Observations By:	KC, Ecology Unit
Application No.	2020/92546
Proposed Development:	Outline application (with details of points of access only) for the development of up to 770 residential dwellings (Use Class C3), including up to 70 care apartments (Use Classes C2/C3) with doctors surgery of up to 350 sq m (Use Class D1); up to 500 sq m of Use Class A1/A2/A3/A4/A5/D1 floorspace (dual use), vehicular and pedestrian access points off Blackmoorfoot Road and Felks Stile Road and associated works.
Location:	Land off, Blackmoorfoot Road and Felks Street, Crosland Moor, Huddersfield, HD4 7AD
OS Map Reference	SE 411329.1154 414683.3657
Applicant/Agent:	Gerald Eve LLP
Class:	Other Developments

Consultation Response from KC, Ecology Unit		
2020/92546 Land off, Blackmoorfoot Road and Felks Street, Crosland Moor, Huddersfield, HD4 7AD		
Outline application (with details of points of access only) for the development of up to 770 residential dwellings (Use Class C3), including up to 70 care apartments (Use Classes C2/C3) with doctors surgery of up to 350 sq m (Use Class D1); up to 500 sq m of Use Class A1/A2/A3/A4/A5/D1 floorspace (dual use), vehicular and pedestrian access points off Blackmoor

Project	Land off Blackmoorfoot Road and Felks Stile Road, Huddersfield
Drawing Title	Habitat Features Plan
Scale	As Shown (Approximate)
Drawing No.	10925/P03
Date	August 2020
Checked	SJC/JM

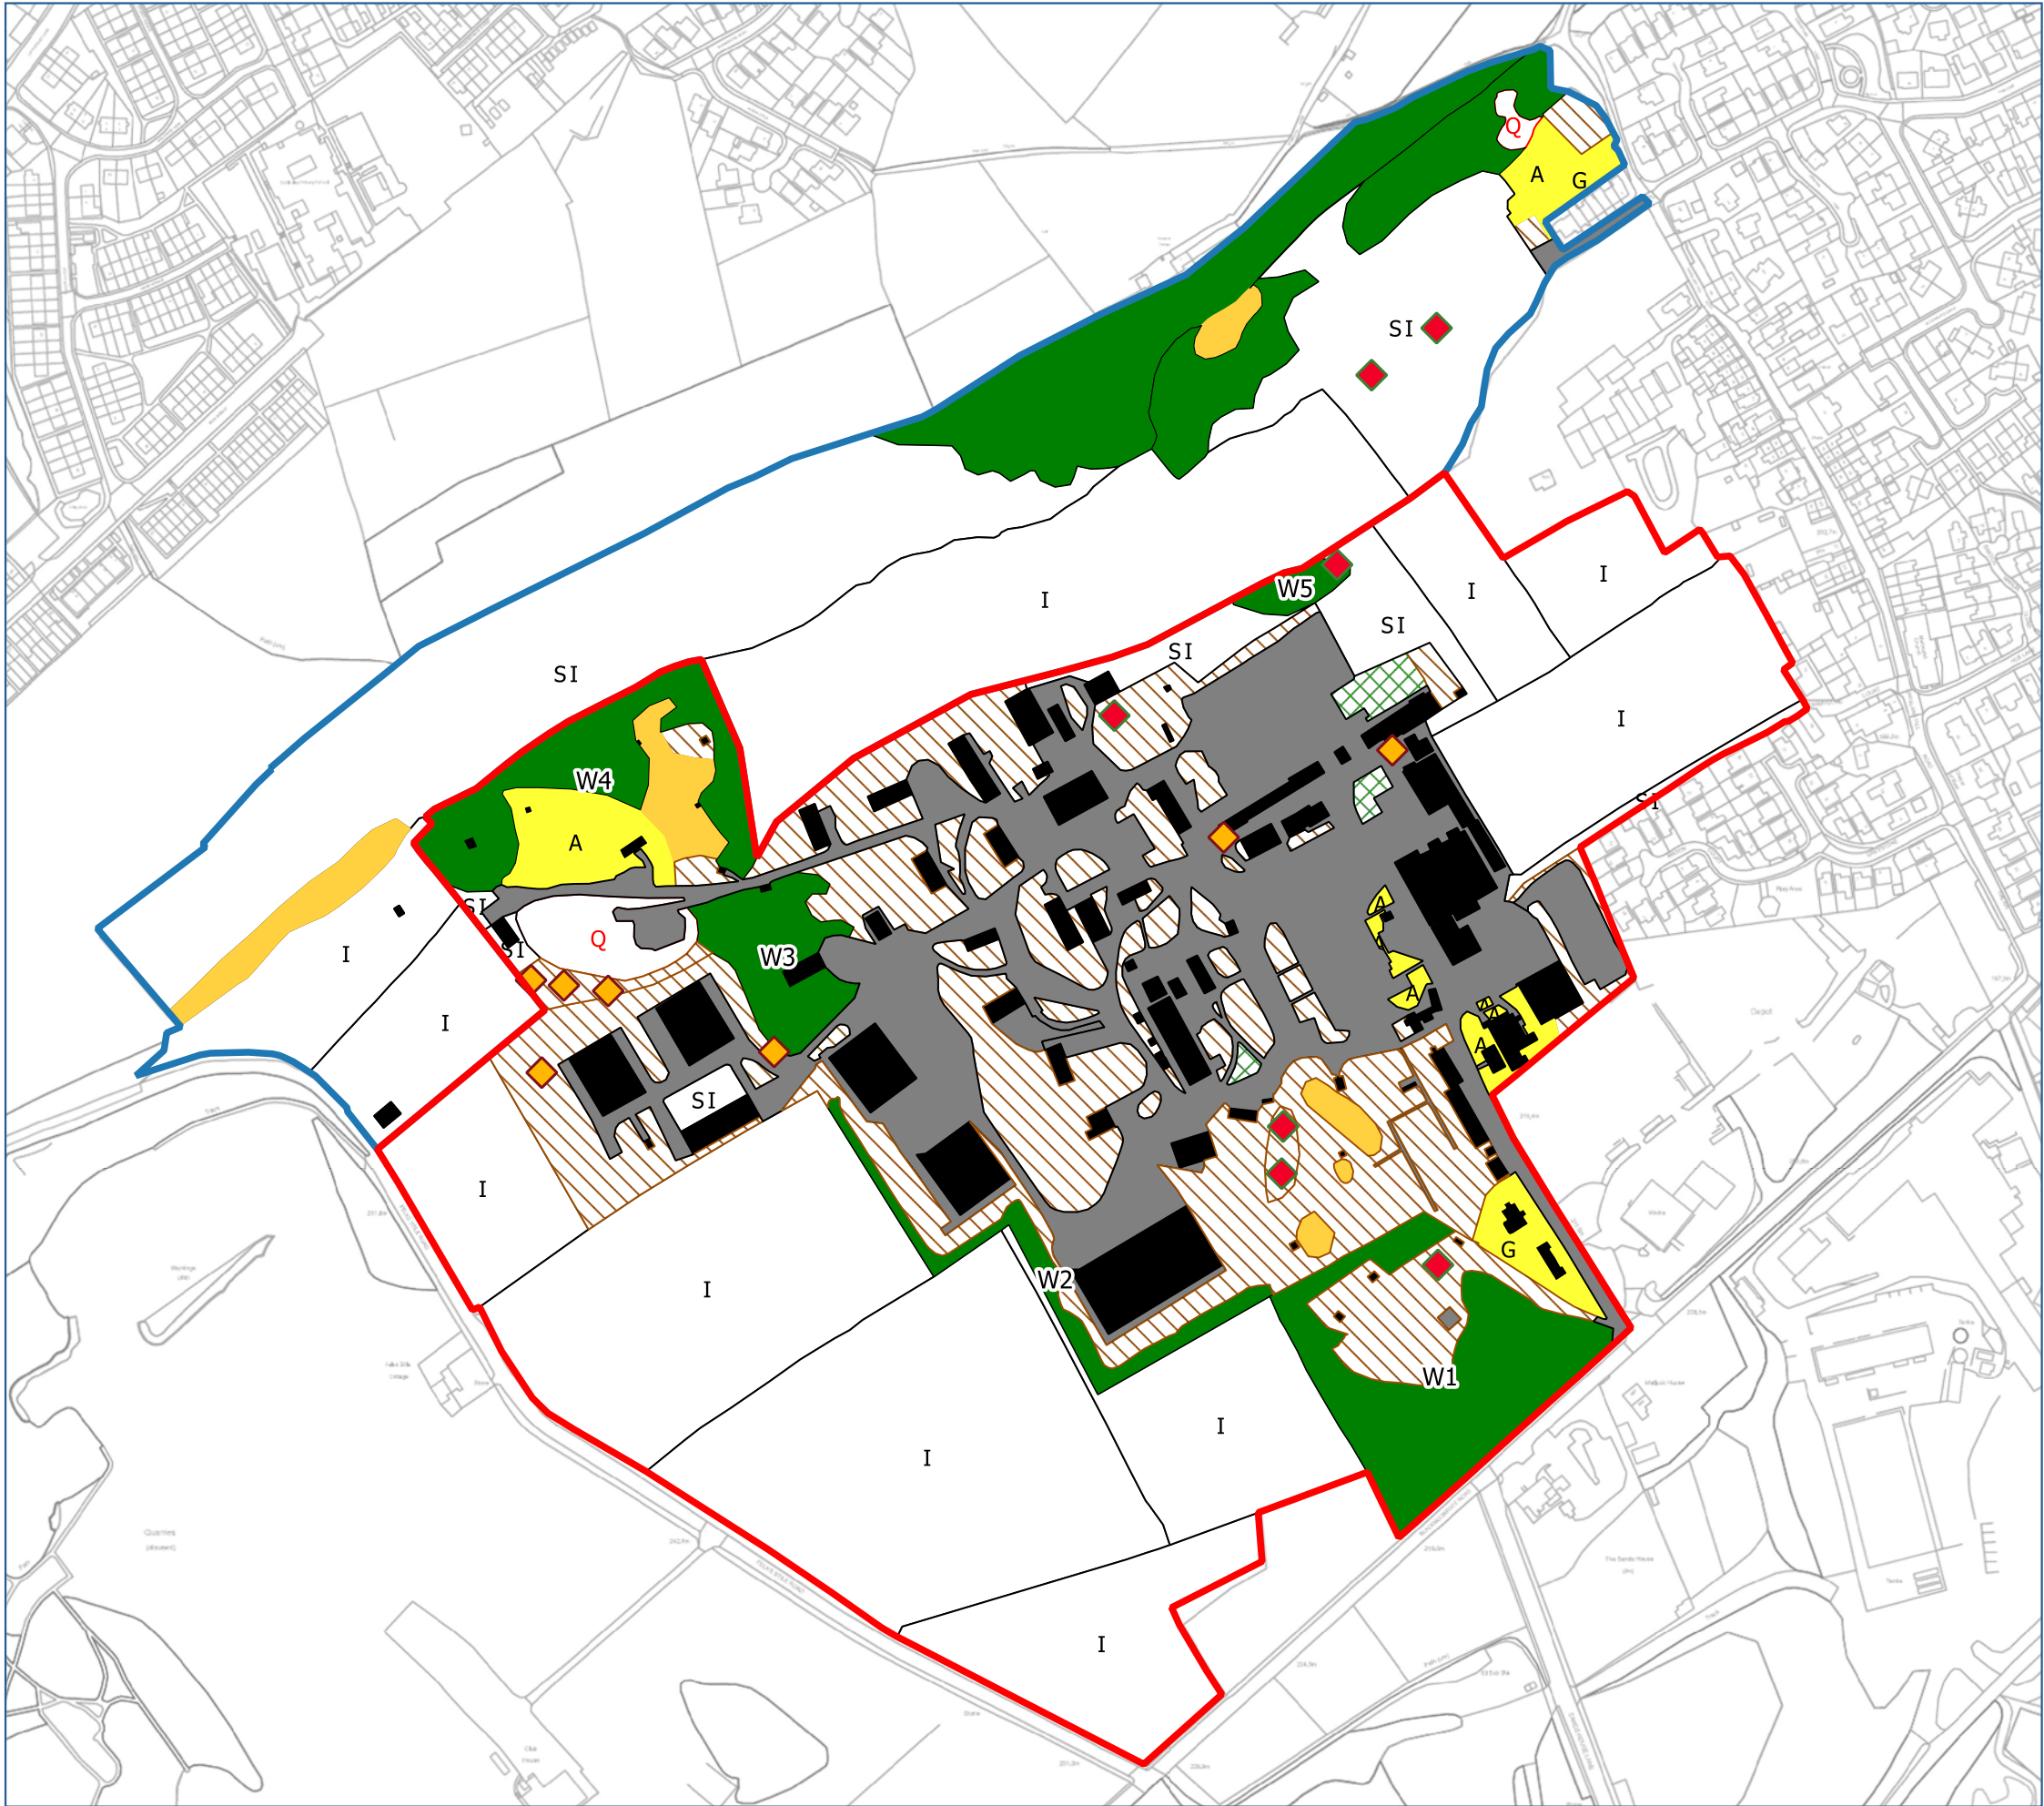
The current plans indicate that areas of woodland (W1, W2 and W3) and heathland, which are considered of local importance, are to be removed to facilitate the development proposals. Heathland is also considered to be a habitat of principal importance within Kirklees. Therefore, the removal of these habitats is undesirable, and the lack of adequate mitigation or compensation does not demonstrate correct application of the mitigation hierarchy.

The use of the biodiversity metric is welcomed however, the calculations further illustrate that the areas of heathland require replacement of the same habitat and the woodland the same broad habitat in order to address the losses. There are also some errors in the metric which require addressing in order to accurately reflect the biodiversity value pre and post-development-

- The ecological assessment identified an area of semi-improved grassland on the site, however only modified grassland is accounted for within the metric. Further clarification on the classification of this habitat within the attached metric is required.
- The post-development habitats of suburban mosaic and amenity grassland have been assigned a condition of 'moderate', this is considered an error in the metric due to be revised in future updates. Therefore, these habitats should be assigned a condition of 'poor'. This amendment results in a change to the habitat units provided, resulting in a -36.24% loss post- development.

With the changes to the post-development habitats the current proposals do not demonstrate that a biodiversity net gain can be achieved on the site. However, the ecological appraisal does make several recommendations for habitat enhancement and creation which could be incorporated into the scheme in order to achieve a net gain. These measures will need to include suitable mitigation for the loss of heathland and woodland, which will require the same habitats to be created and no net loss of woodland cover on the site. Options to include these within the open space/green infrastructure on the site and within the blue line boundary should be explored to inform the final designs and layout of the site. In order for the proposals to accord with National and Local policy, a 10% net gain in biodiversity will be required post-development.
